COLORADO SPRINGS UTILITIES  
2021 NE GRAVEL STAGING AREA RELOCATION

SITE DEVELOPMENT PLAN

PCD File No. U-21-001 and PPR-21-050  
Colorado Springs Utilities NE Gravel Staging Area  
Site Development Plan Checklist

**PROPOSED STAGING YARD**

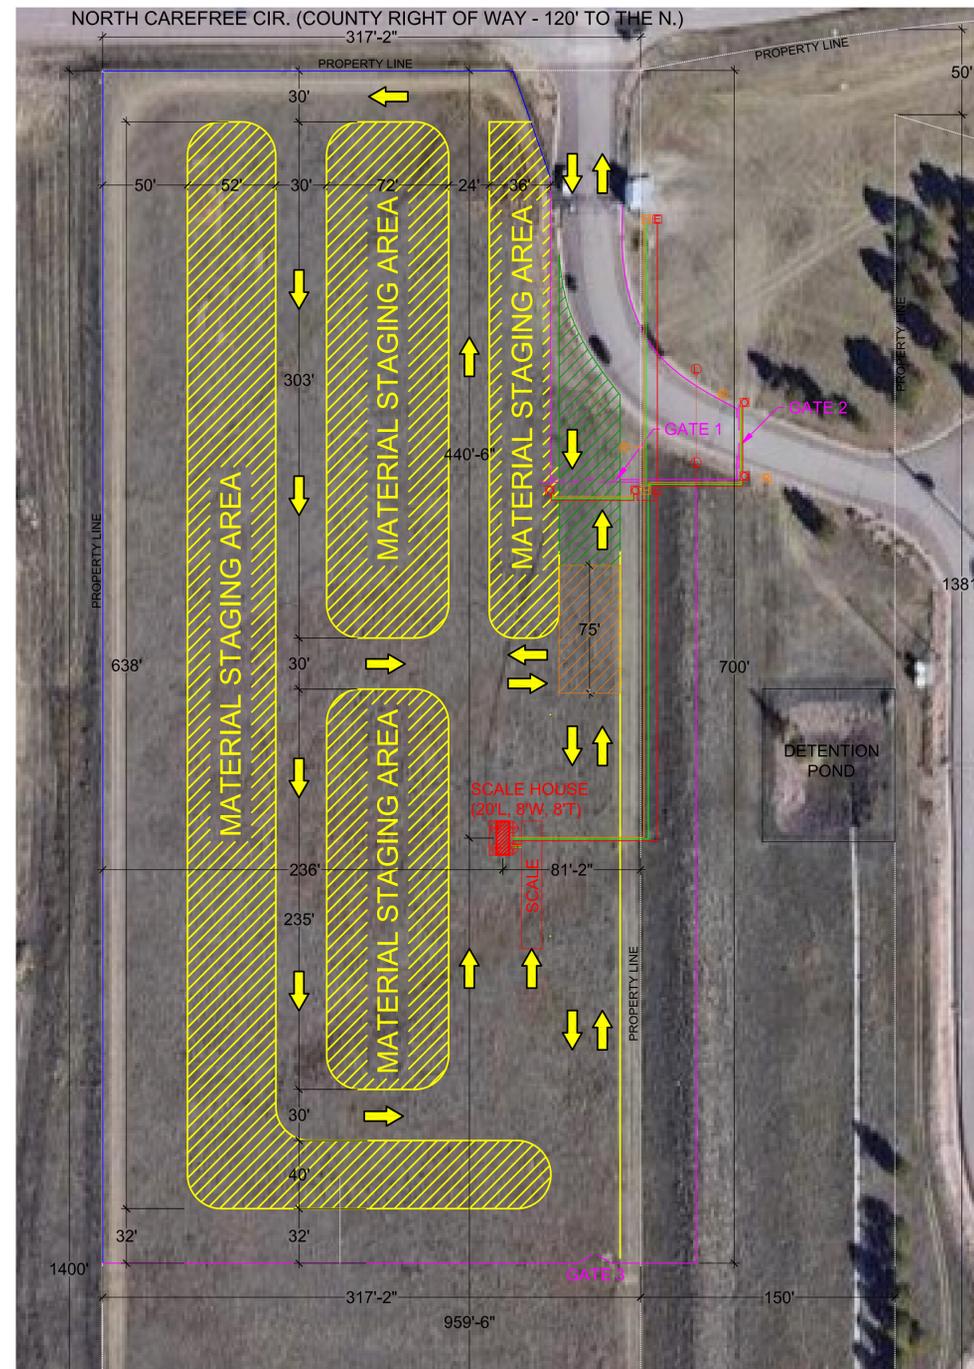
This site plan still does not depict the proposed 7 ft tall fence
